**WEST SUSSEX COUNTY COUNCIL
STRATEGIC PLANNING CONSULTATION**

**FROM: Alison Meeus TO: Arun District Council
FAO: Simon Davis**

SUBJECT: BR/249/13 - Change of Use of ground floor from Motor Vehicle Sales & Servicing/Repairs (Sui Generis) to A1 (Shops) Food Retail.

Nyetimber Mazda, 33, Chichester Road, Bognor Regis, West Sussex, PO21 2XH

Site Plan

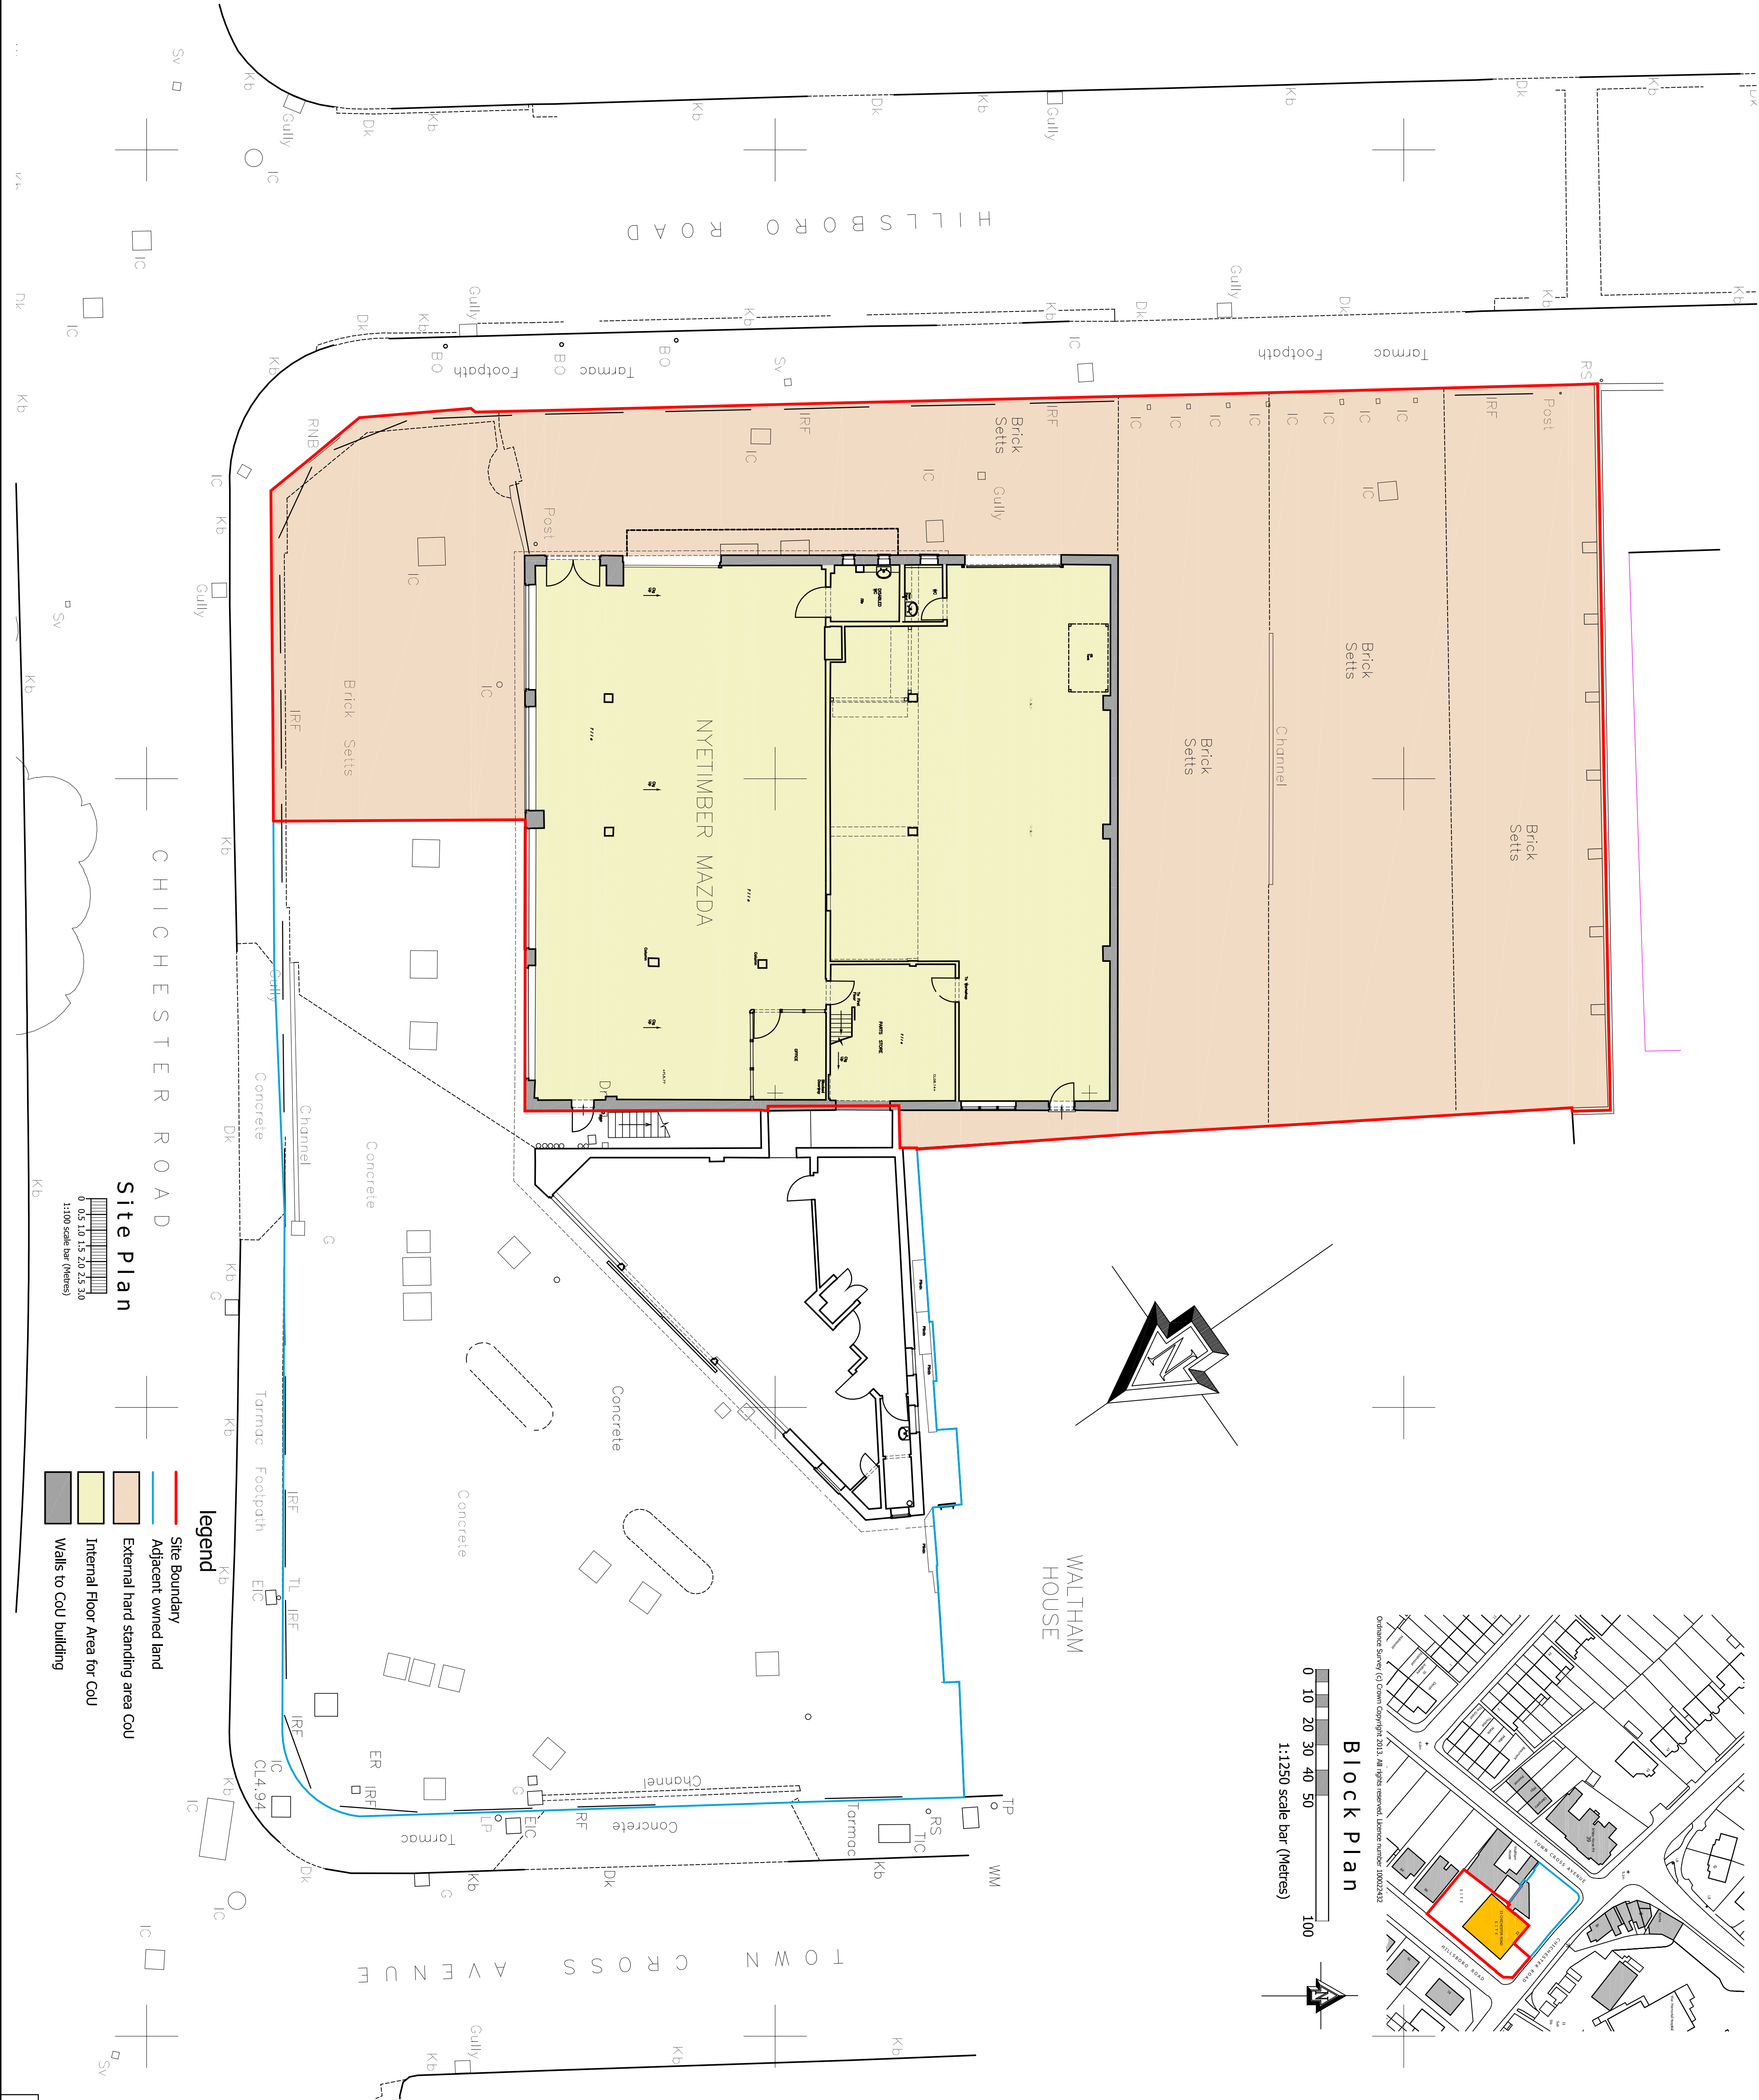
The proposals include the re-use of the 18 space car park, to provide 15 spaces, with the remaining three spaces kept back and used for bin storage. This will provide parking for customers and staff. It is anticipated that there will be 20 employees at the store, with approximately 5-8 staff working at any one time. WSCC car parking standards recommend that the expected car parking demand for A1 use is 1 space per 14sqm, and the development should provide 22 spaces, 5% of these should be designated disabled parking. As the car park has been in use as part of the existing establishment WSCC are satisfied that the parking spaces set out meet current standards. However; as the proposed number of spaces is below our recommended standard, WSCC have undertaken a review of a selection of car parking accumulation surveys, submitted by the applicant, to ensure the 15 spaces proposed meet the expected demand.

WSCC has asked the applicant to provide some clarification regarding the existing uses alongside the new development and its car parking demands. As such, the highway authority has considered this information on its merits and considers that although the existing use will generate some vehicle trips these can most likely be accommodated within the existing site forecourt or within the surrounding roads.

No part of the development shall be first occupied until the car parking spaces have been constructed in accordance with plans and details submitted to and approved in writing by the Local Planning Authority. These spaces shall thereafter be retained at all times for their designated use.
